24 April 2020

SECTION 4.55(2) MODIFICATION 3 TO SSD 7037 | 75-85 HARRINGTON STREET, THE ROCKS | RESPONSE TO SUBMISSIONS

project code GA85H sheet no. DA-4151 revision A7

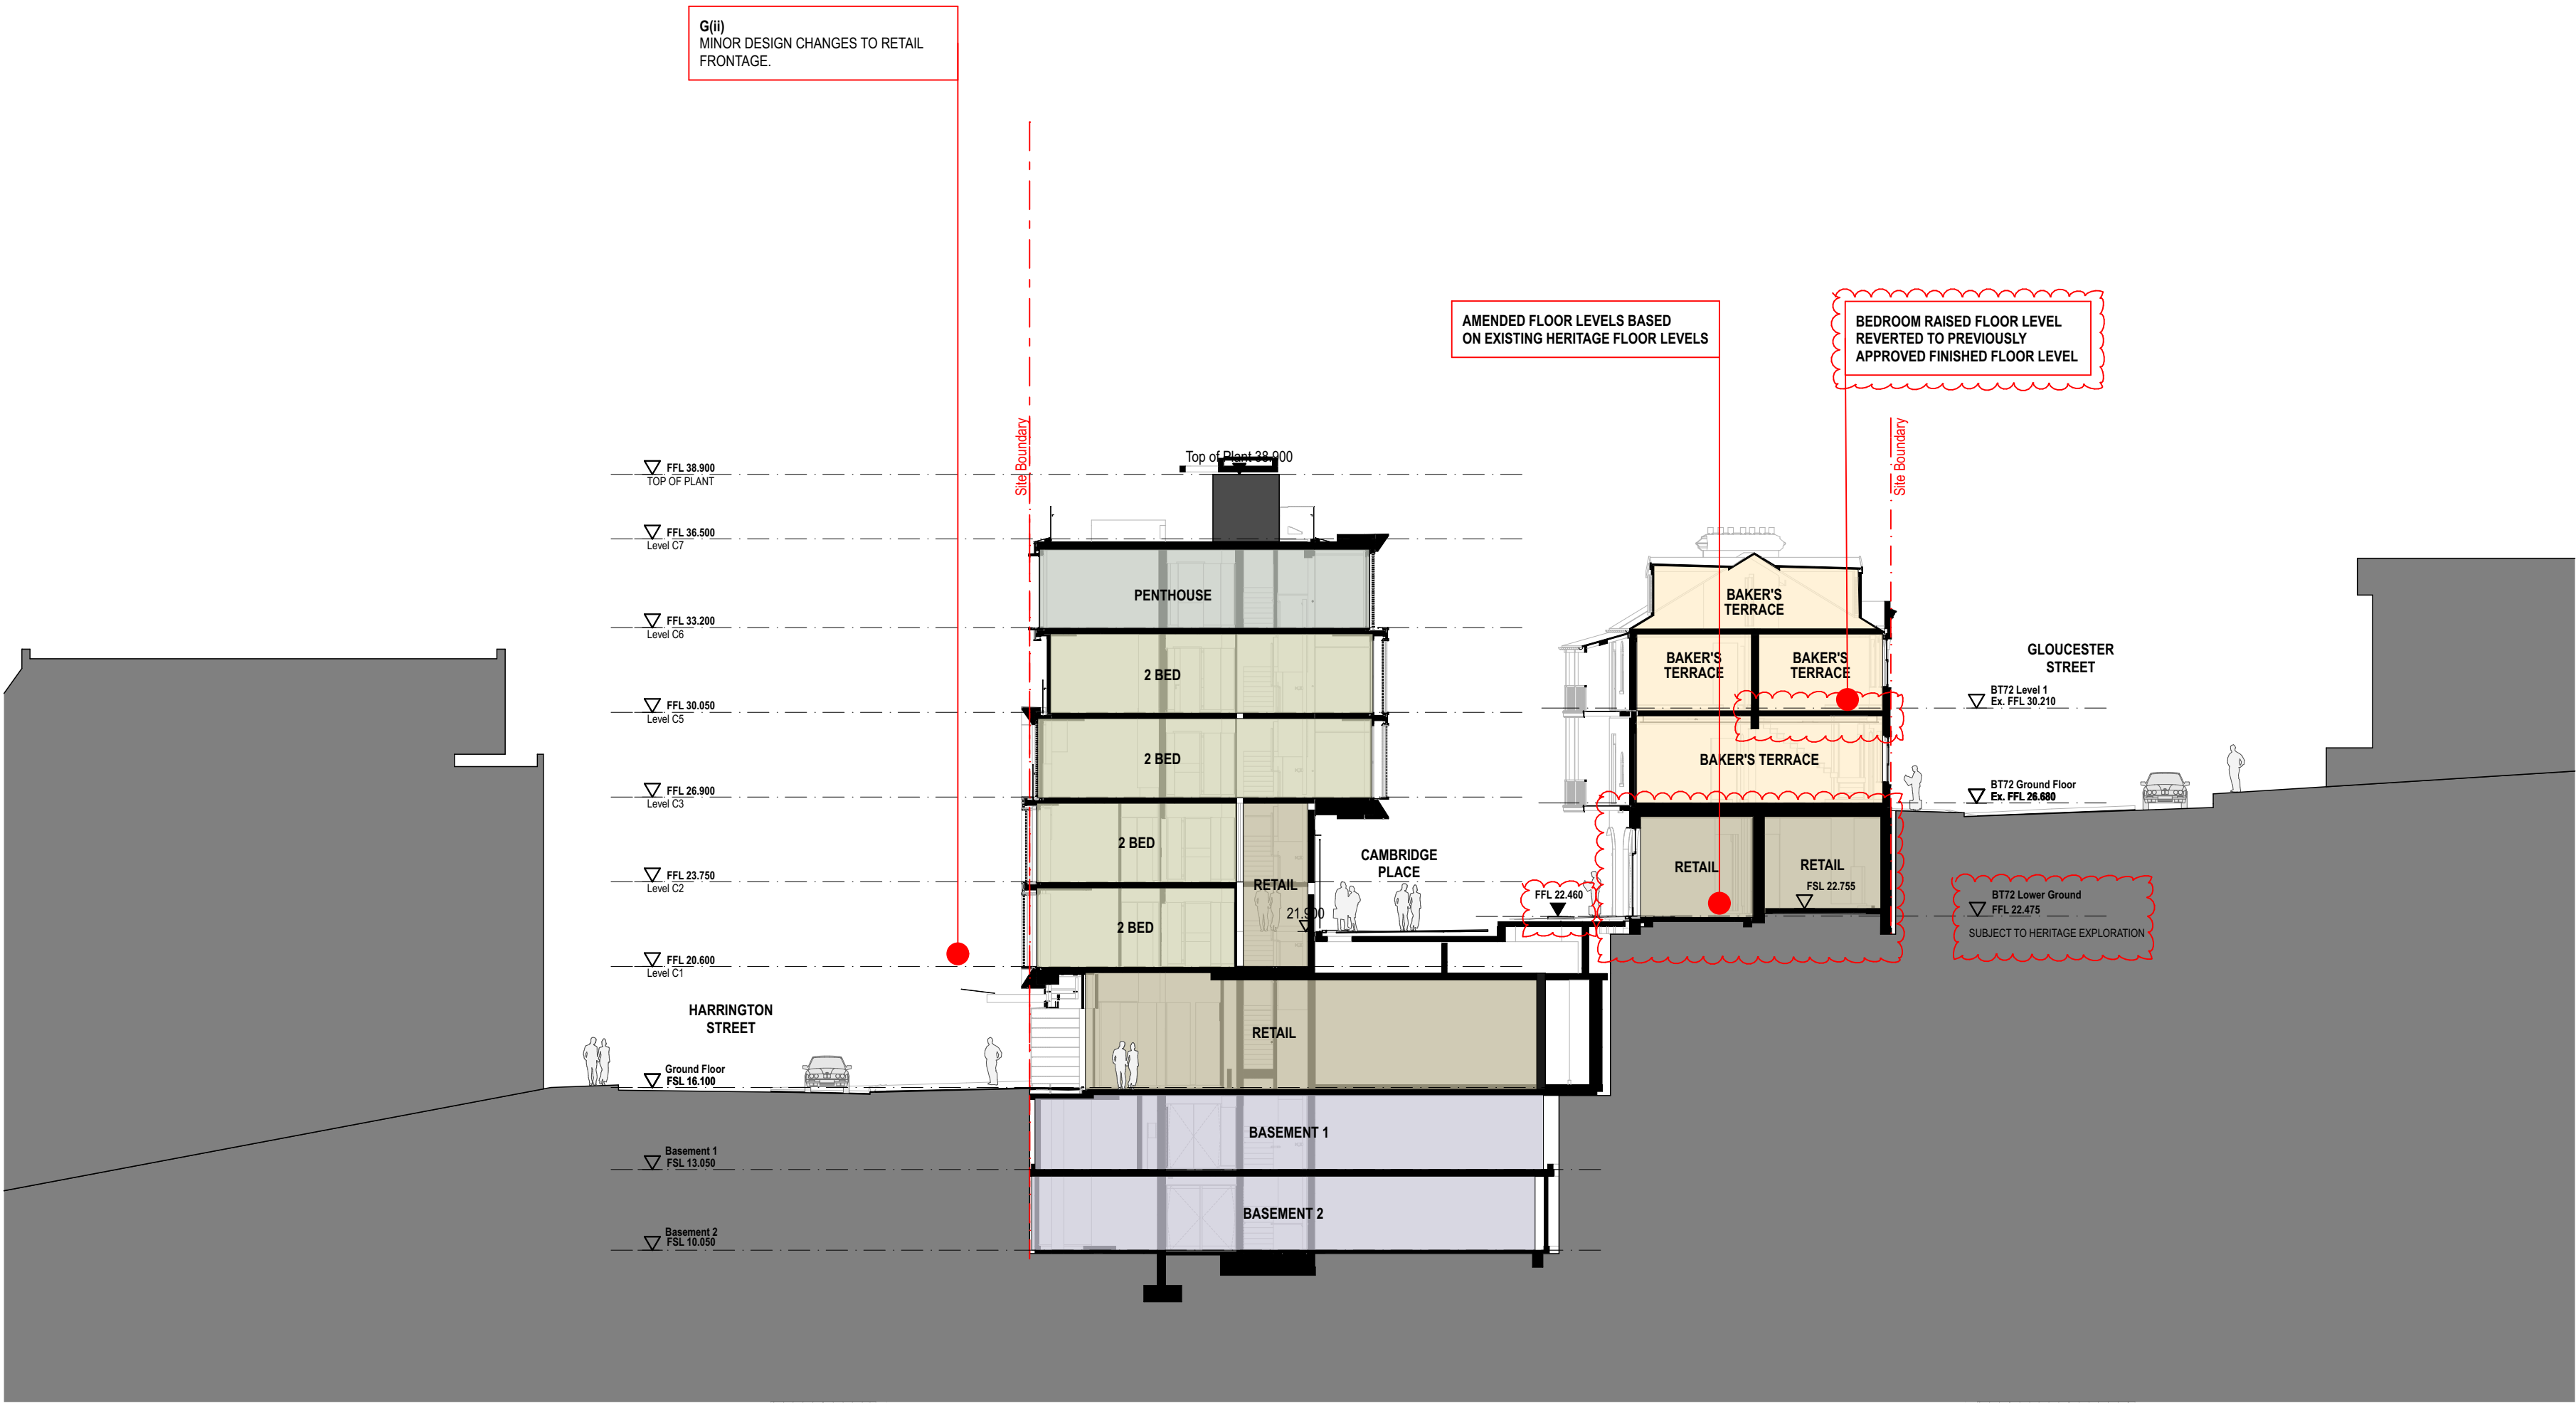
- Raising the Bakers Terrace basement FFLs by approx. 200mm to avoid archaeology impacts. Associated with this, one additional tread has been added to the Cambridge Place steps to align with revised FFLs.
- Reverting raised floor level in the BT68 bedrooms (as per originally submitted and approved DA).
- Removing walls which were previously assigned heritage significance (before it was known they are 1990s infill).
- Kitchen layout in BT68 has been redesigned to cater to heritage limitations for the window-sill heights. No external profile (façade) or GFA amendments.
